CITY OF ALBUQUERQUE

July 5, 2017

**Re: U-Haul Center Coors and I40
Erosion and Sediment Control Plan
Engineer's Stamp Date 6-5-17 (H11E059)**

#### Erosion Sediment Control Plan

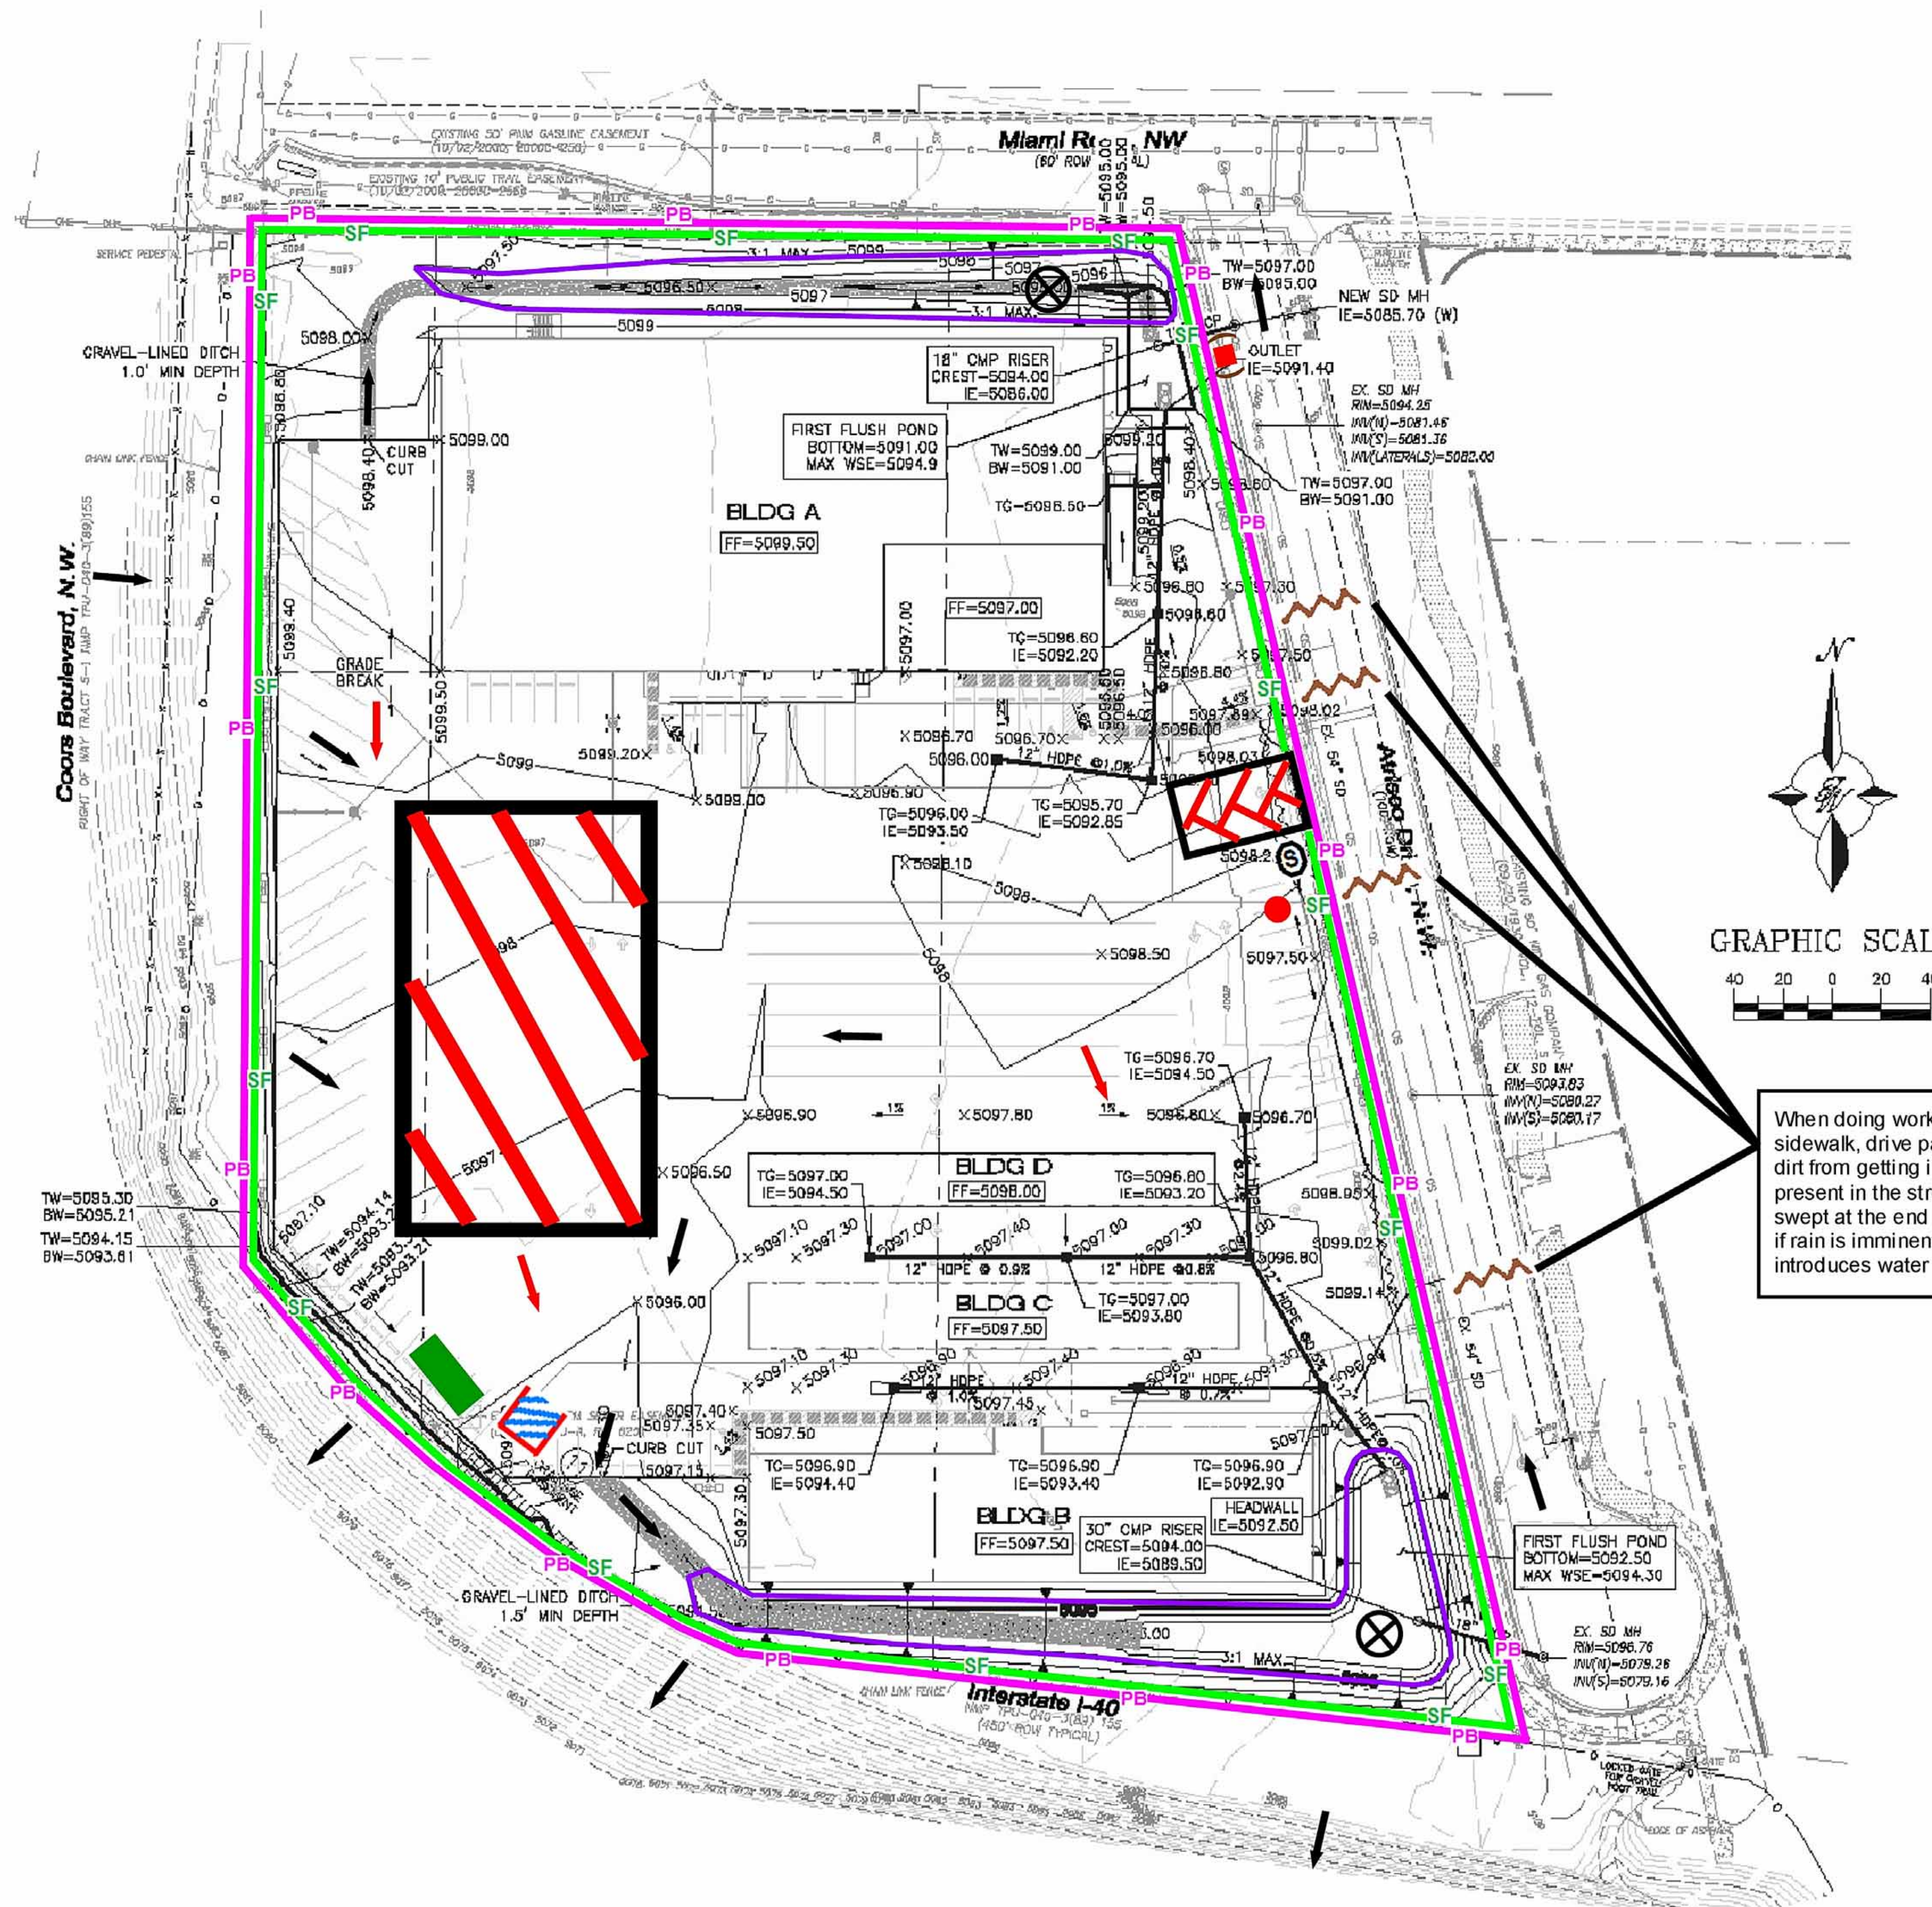
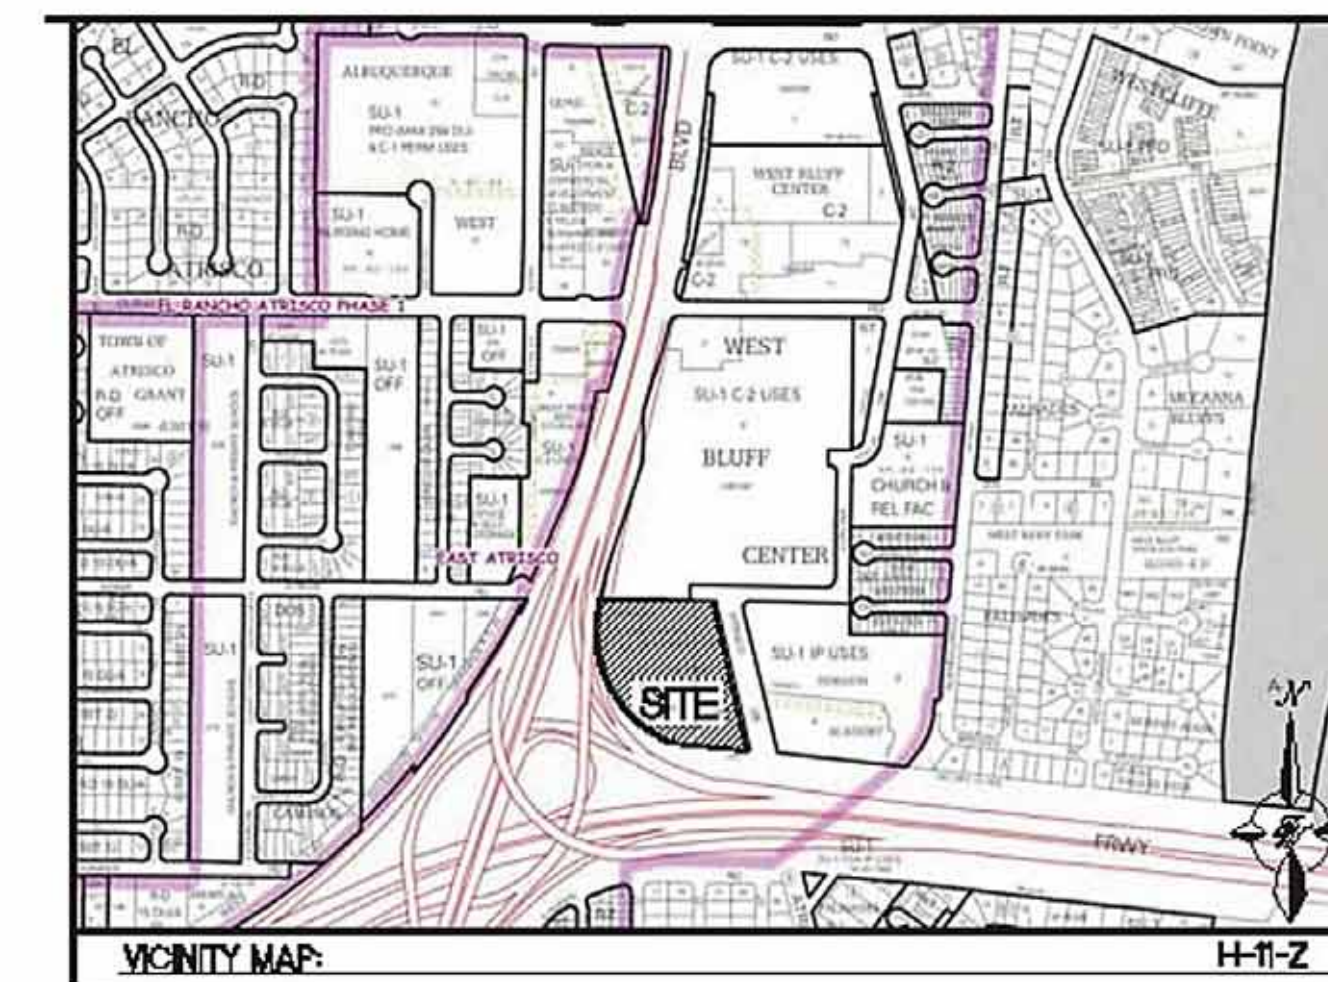
The plan was not approved for an ESC Permit for grading and Building Permit, because it did not propose inlet protection for the onsite pond outfalls. A separate plan was previously approved to apply for an ESC Permit for grading and Building Permit.
